Application No: EP/128/20/HH
Site Address: 48 Angmering Lane East Preston BN16 2TA
Description of works: Erection of a two storey rear extension. Existing brick house to be rendered in white with alterations to fenestration

Thank you for your internet representation made on 13th November 2020 which has been recorded as an objection with the comments as follows:

0008 Proposed First Floor

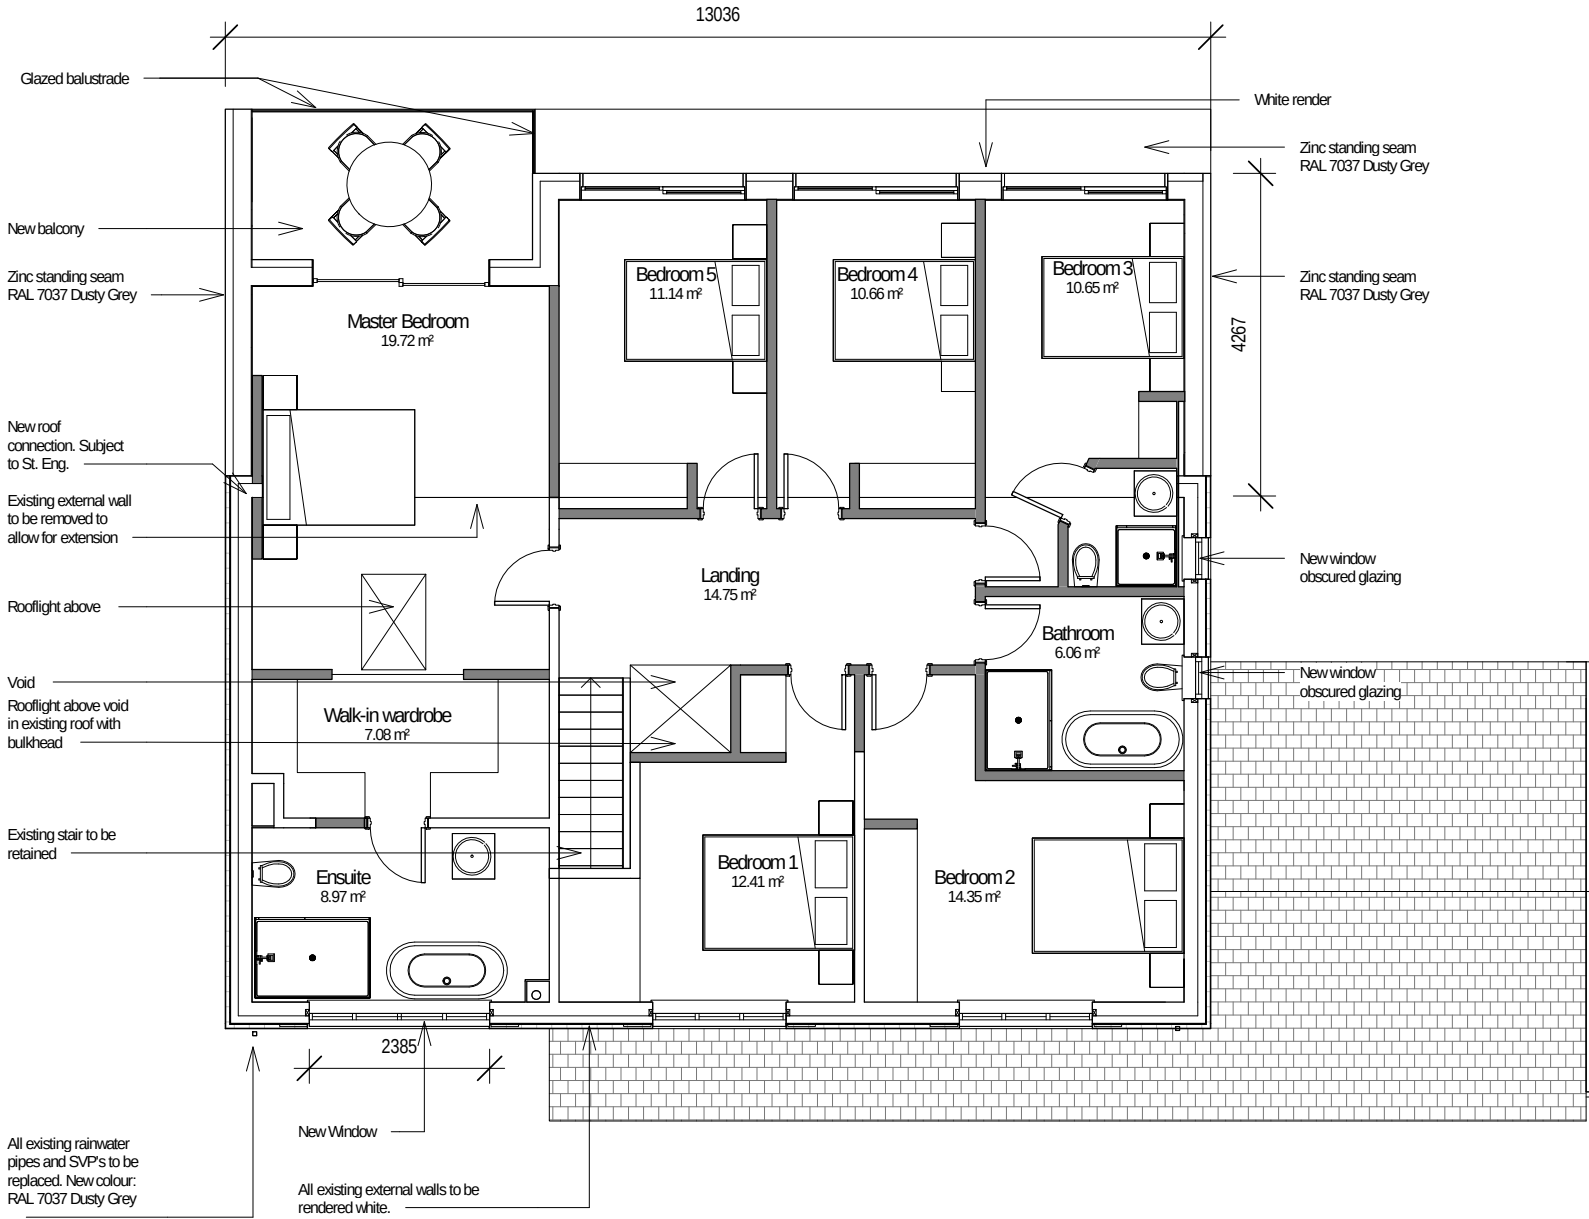
- 3 From the proposed plan it appears the first floor balcony off the Master Bedroom will be large enough to take a table and chairs. As next door neighbours this would severely limit our privacy as anyone sitting out there would have an unrestricted view overlooking our garden.

Drawing No. 0009 Drawing Name: Proposed Roof Plan

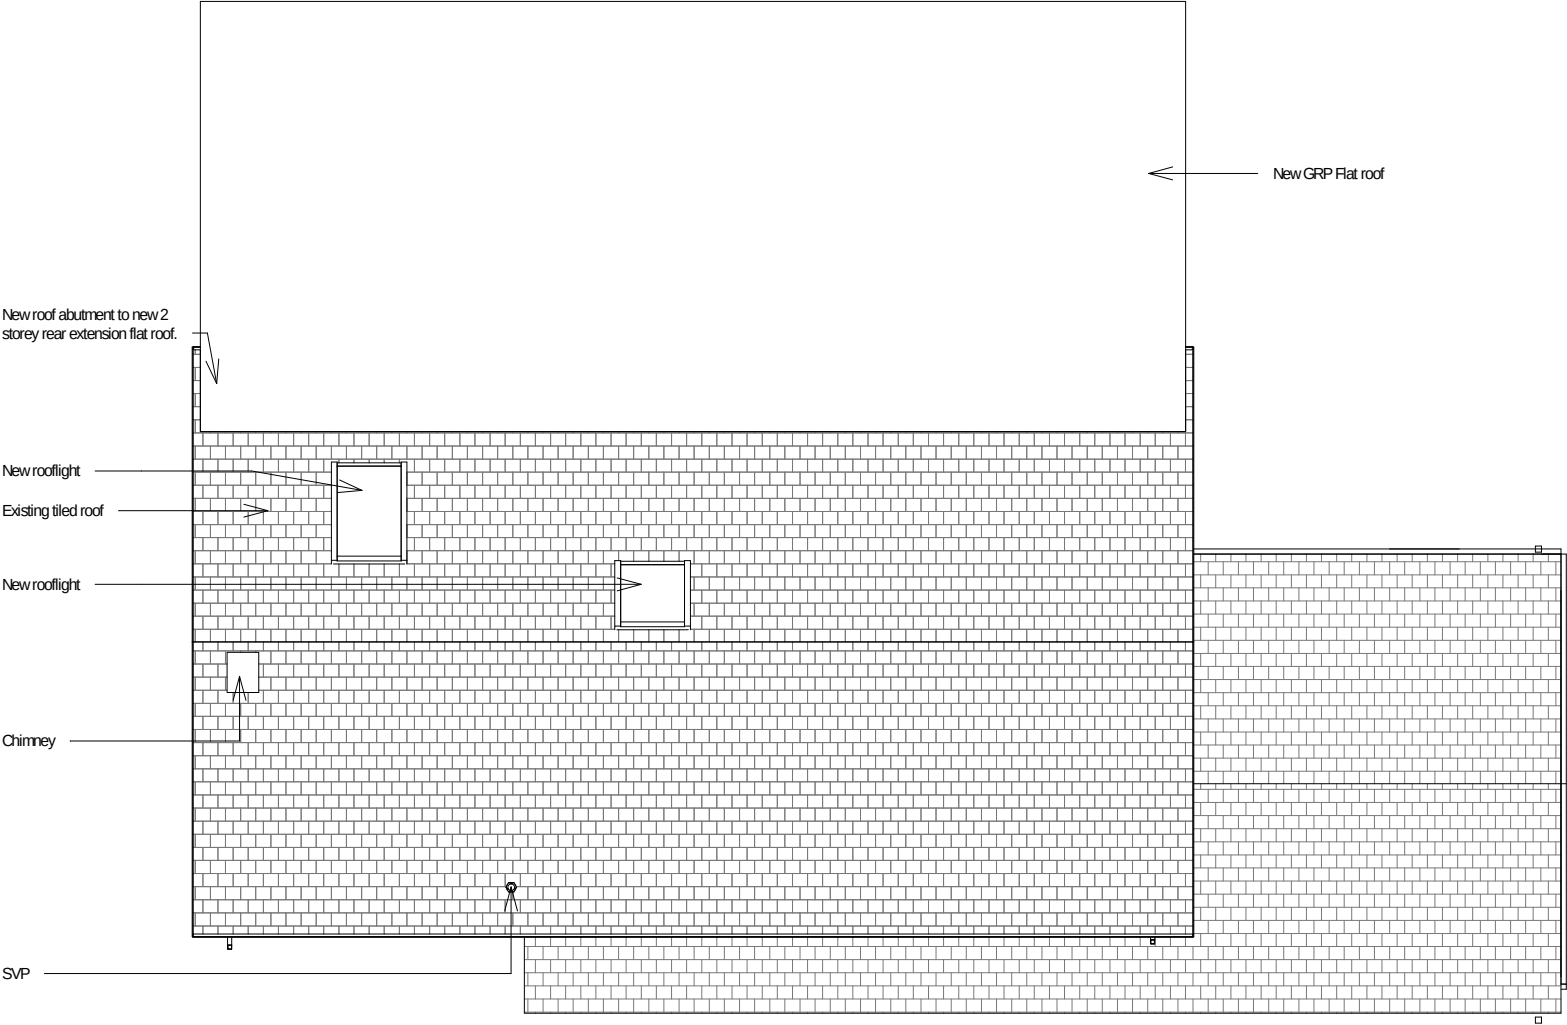
2. The proposed flat roof on the first floor is also not in keeping with the rest of the properties on Angmering Lane. Its proposed height above the present guttering level is obtrusive. It will also be in view of anyone walking in the Lane.

Drawing No. 0010 Drawing Name: Proposed Elevations

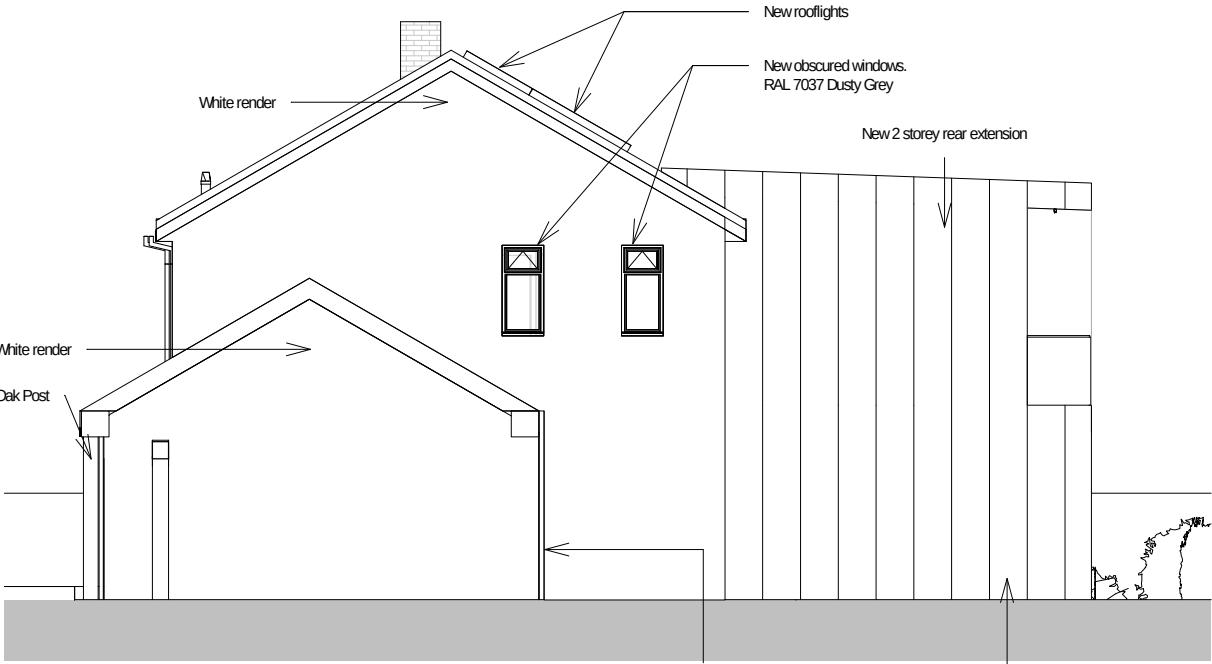
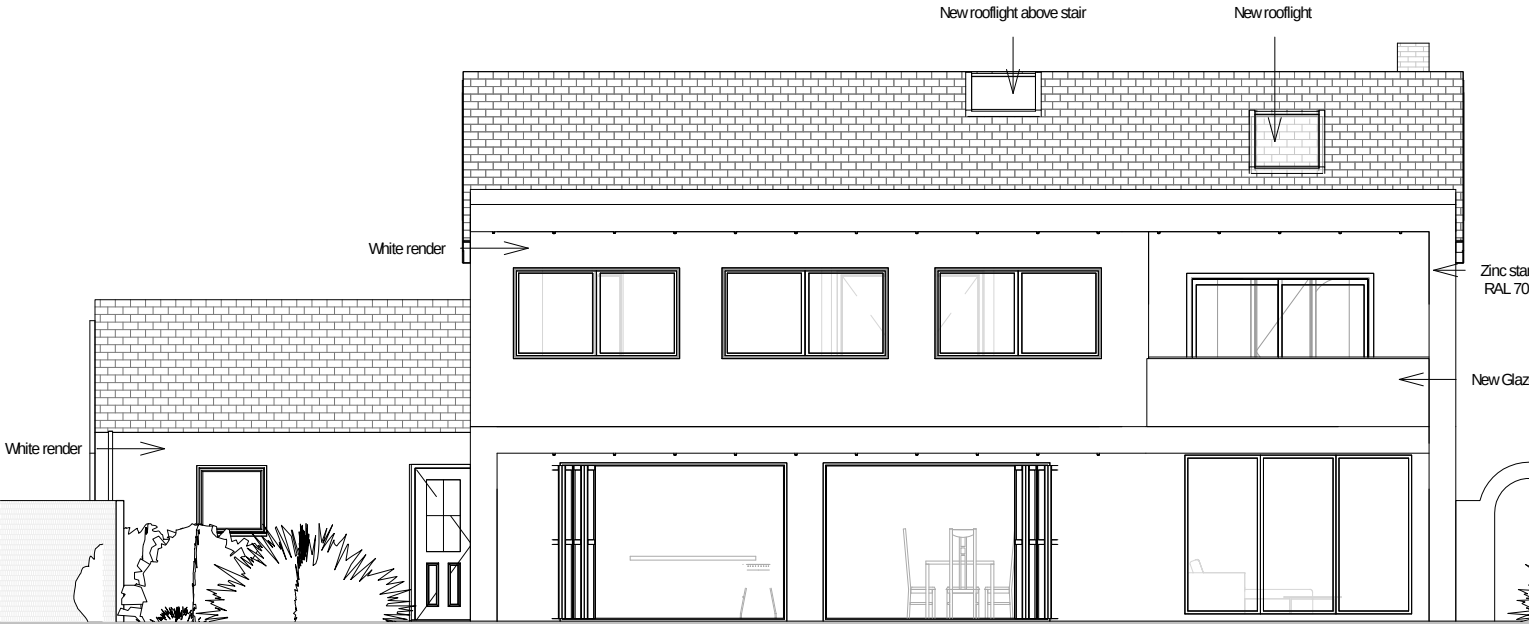
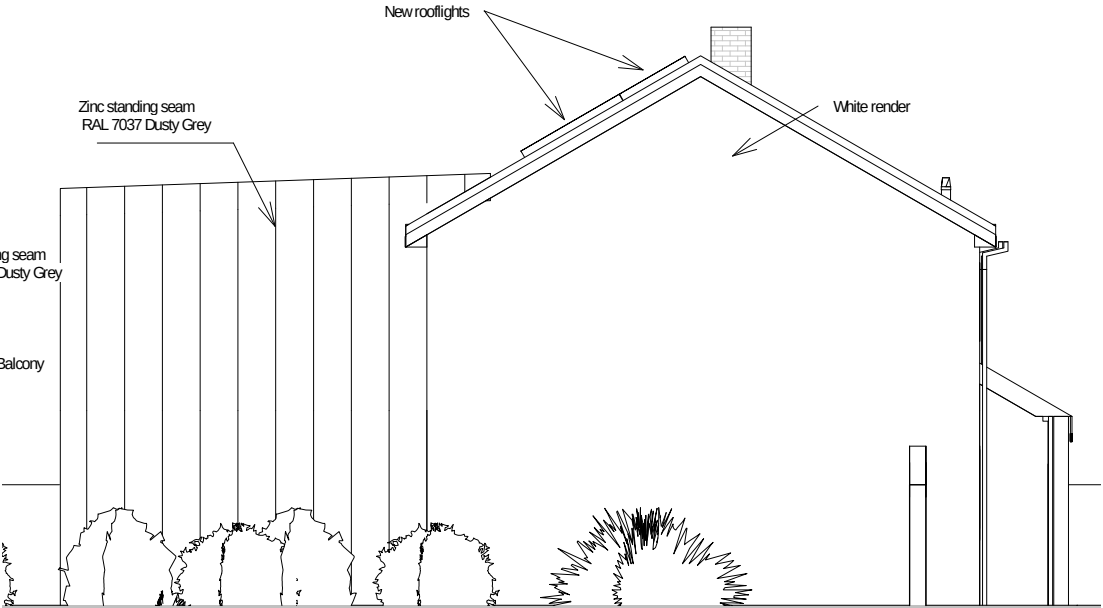
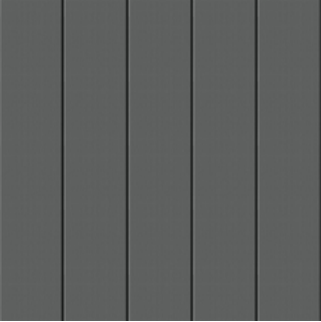
1. The proposed Dusky Grey zinc cladding is entirely out of keeping with other properties in the area and can be seen by anyone walking down Angmering Lane. This cladding is not used on any nearby properties and will therefore be totally out of character with properties surrounding it.

- 4 Para 4.16 of the East Preston Neighbourhood Plan indicates "Extensions should look as if they were part of the original design of the house"
